Consultation Response from KC, Conservation and Design
2020/90609 Tolson Cottage, Dean Brook Road, Armitage Bridge, Huddersfield, HD4 7PB
Erection of detached car port and store (Listed Building within a Conservation Area)
Date Responded: 8.4.20
Responding Officer: Sue Oakley
Responding Ref:

Image of proposed fence.

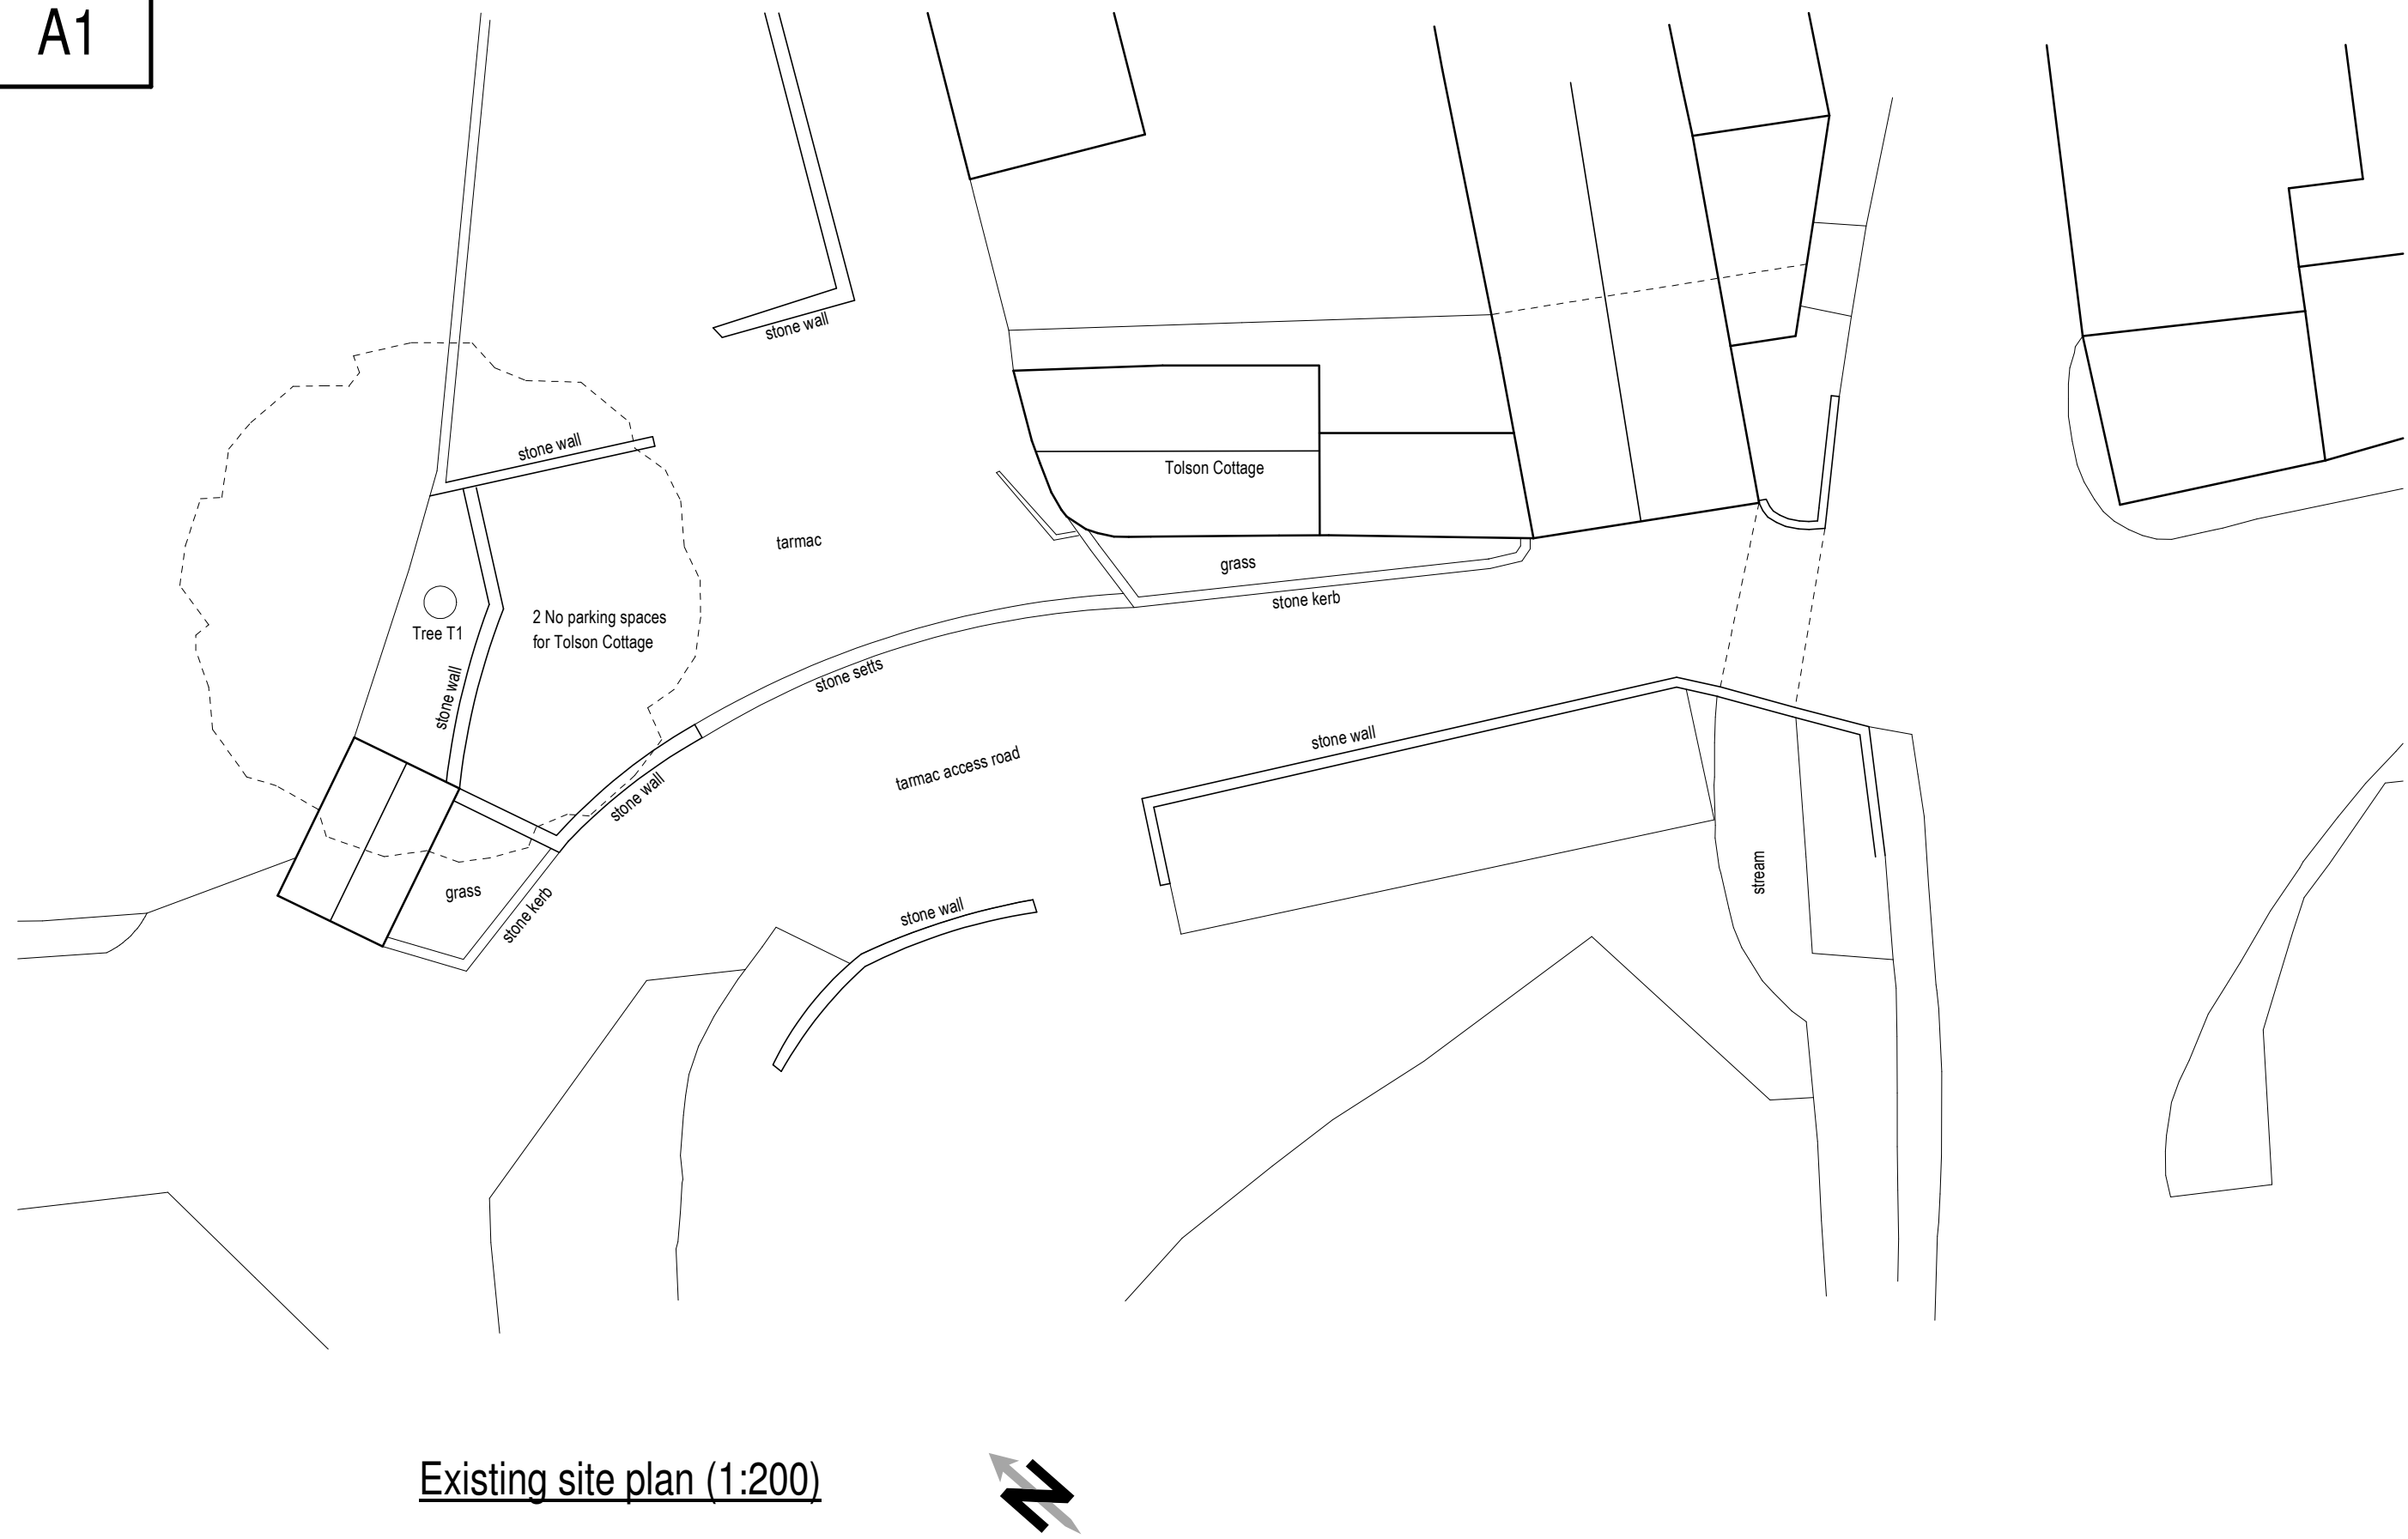
The drawing shows a new fence around the car port, but its height is not provided. The conservation area is characterised by stone walling and a lightweight wire fence around the adjacent field. The construction of a domestic close boarded timber fence will harm the character of this part of the conservation area and should be omitted from the proposal.

I would consider this proposal to cause slight harm to the character and significance of the conservation area and I have concerns about the recent garage conversion being used to justify the proposal as this is a private, not public, benefit. Although the framework of the car port is open, the structure has a pitched slate roof and a solid stone store to one side, which would add to the loss of views and open space within this conservation area.

If this proposal is considered acceptable in principle, I would prefer it to be redesigned to reduce the mass.
